I emailed a revised drawing for the above application to Maria Tomalova and also to [redacted] on the 20th January 2020 requesting that the attached drawing P13a be uploaded and to replace drawing P13. I attach a copy of the email below highlighted in blue. Unfortunately the drawing does not appear to be on the system.

Please find attached a revised copy of drawing P13a. The drawing has been revised to indicate the outline of the previously proposed scheme (ref : Y/74/19/PL) which as illustrated has drastically reduced the overall width of the development as viewed from Hoe Lane and the back garden.

Drawing P13a December 2019 Scale 1:100 @ A3
Planning Drawing - SW & NE Elevation

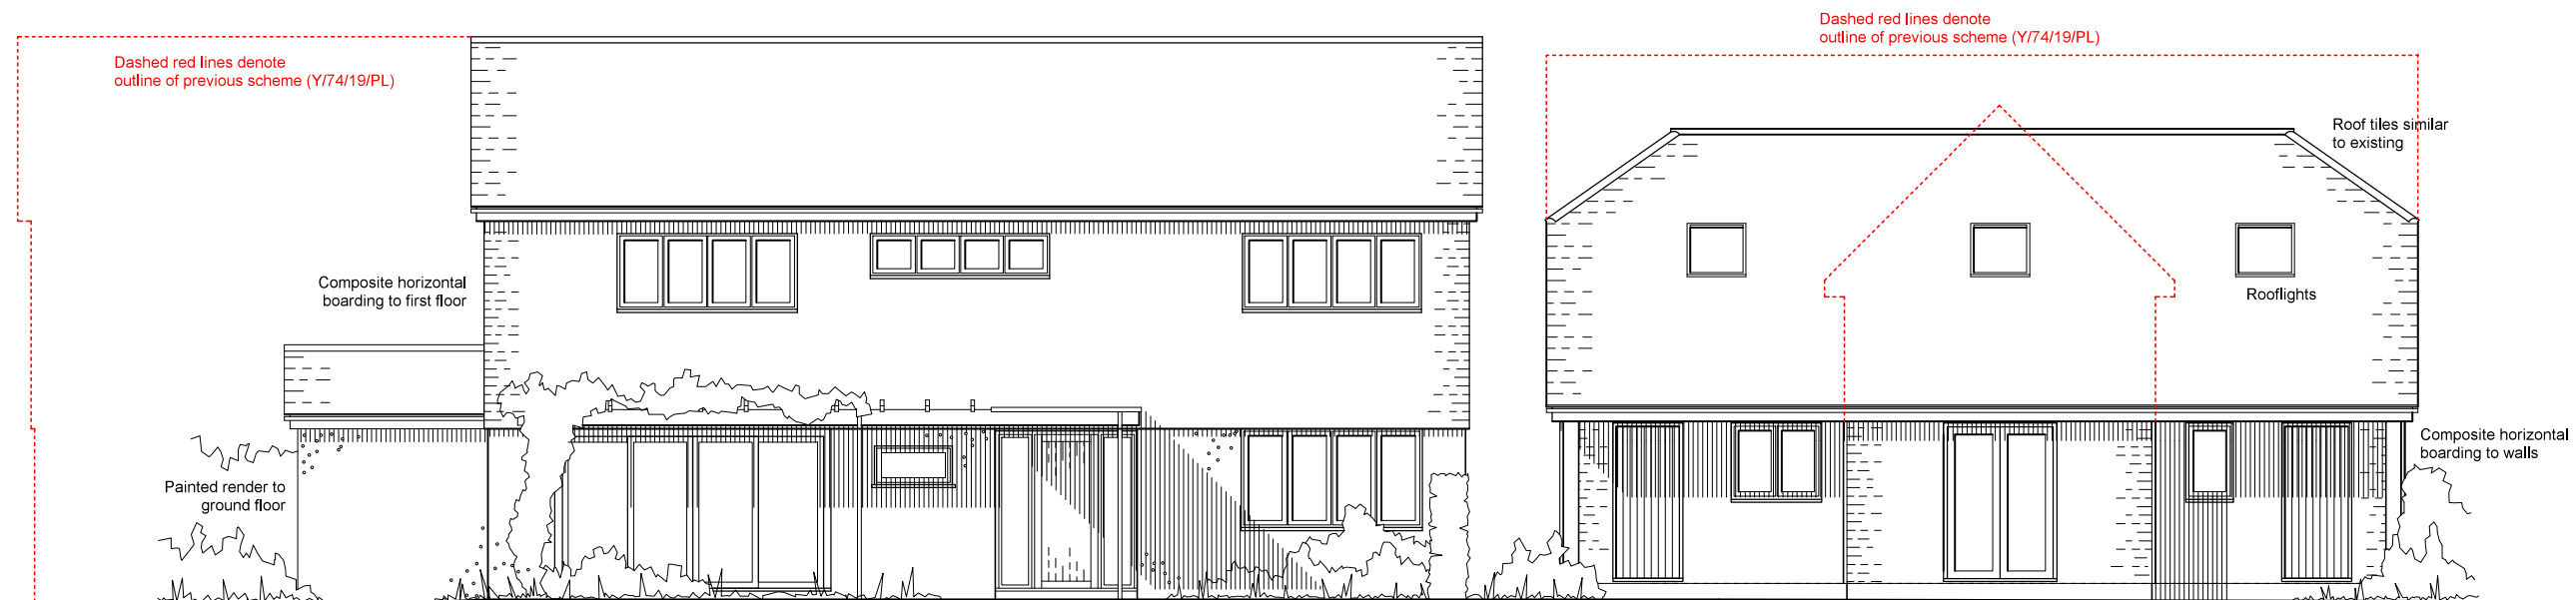
The ridge height of the proposed holiday let is 975mm lower than the previous scheme and the large dominant gable end has been replaced with a simple half hipped pitched roof. While the central section of front wall is in the same position as the existing wall, the front walls either side are stepped back 1m and therefore reinforcing the subservient nature of the development.

The house maintains it's current width albeit with a small utility room side extension the distance of which is at least 5.8m to the boundary (considerably more than a lot of properties on Hoe Lane).

May we request that the attached drawing P13a is uploaded to the file and is substituted for drawing P13.
